NC DEPARTMENT OF
**HEALTH AND
HUMAN SERVICES**

August 28, 2020

Subject: 171 Piney Field Road, Mason Pointe Subdivision Lot 39
LHD Request for Review – Session Laws 2013-413 and 2014-120
Project Number: 2020-36

PLAN:
240.3174-R
SHEET:
1.1

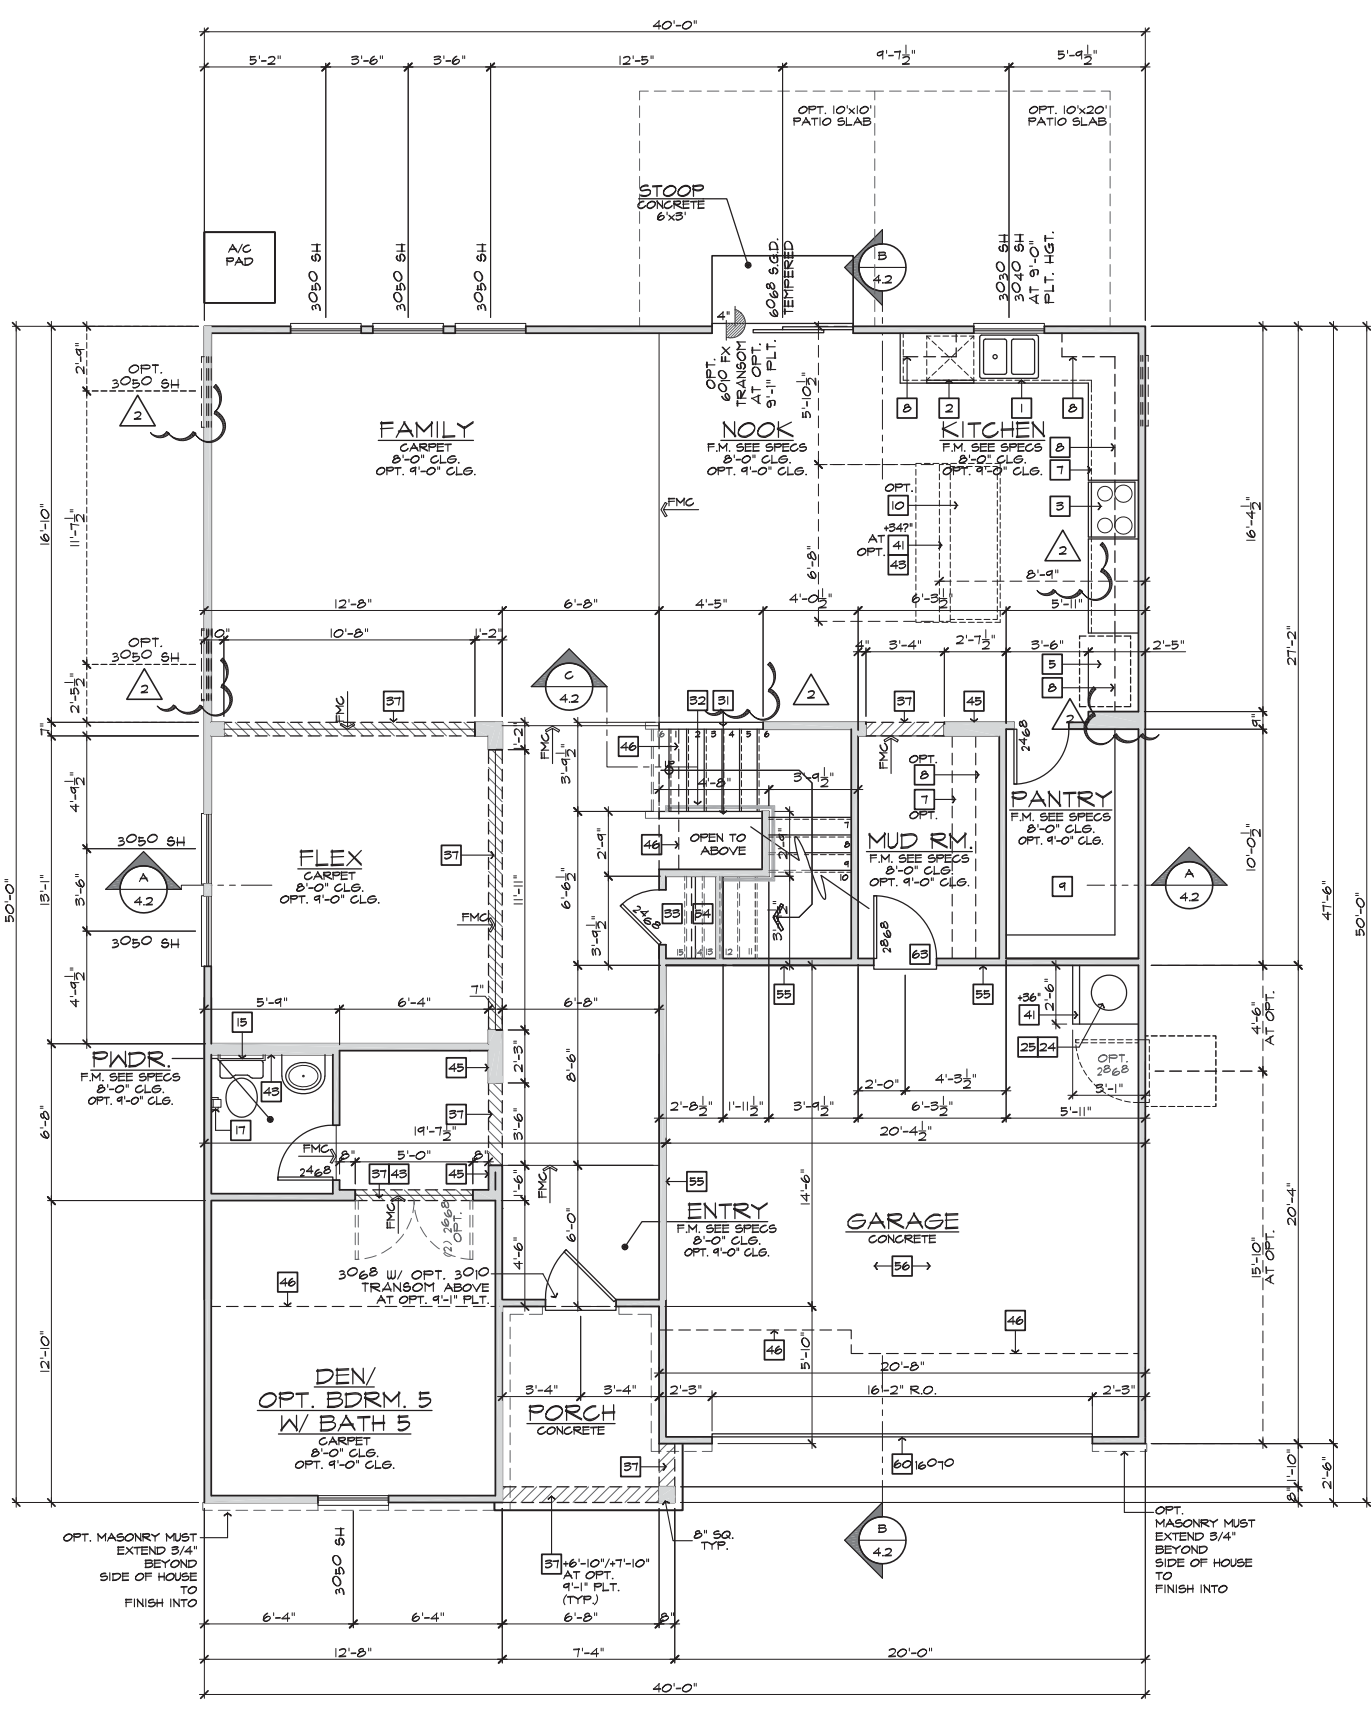
5. Observations: Floor Plan Sheets and Fixtures Table
 - a. The scale of the floor plan sheets 1.1 and 1.2 included in the submittal was so small (1" \approx 12.9') that a magnifying glass was required during attempts to ascertain fixtures information on those pages. Floor plans including in future submittals are to be at a scale no smaller than 1" = 5'.

- b. The fixtures table indicates a tub/shower fixture in the Optional Bath (Bath 5), but I was unable to visually identify a location of this fixture on plan sheet 1.1. Is there such a fixture in Bath 5?

- c. Are there any water-using fixtures in the mud room?
6. Prior to issuing a revised IP/CA, it is strongly recommended that you have all the following information:
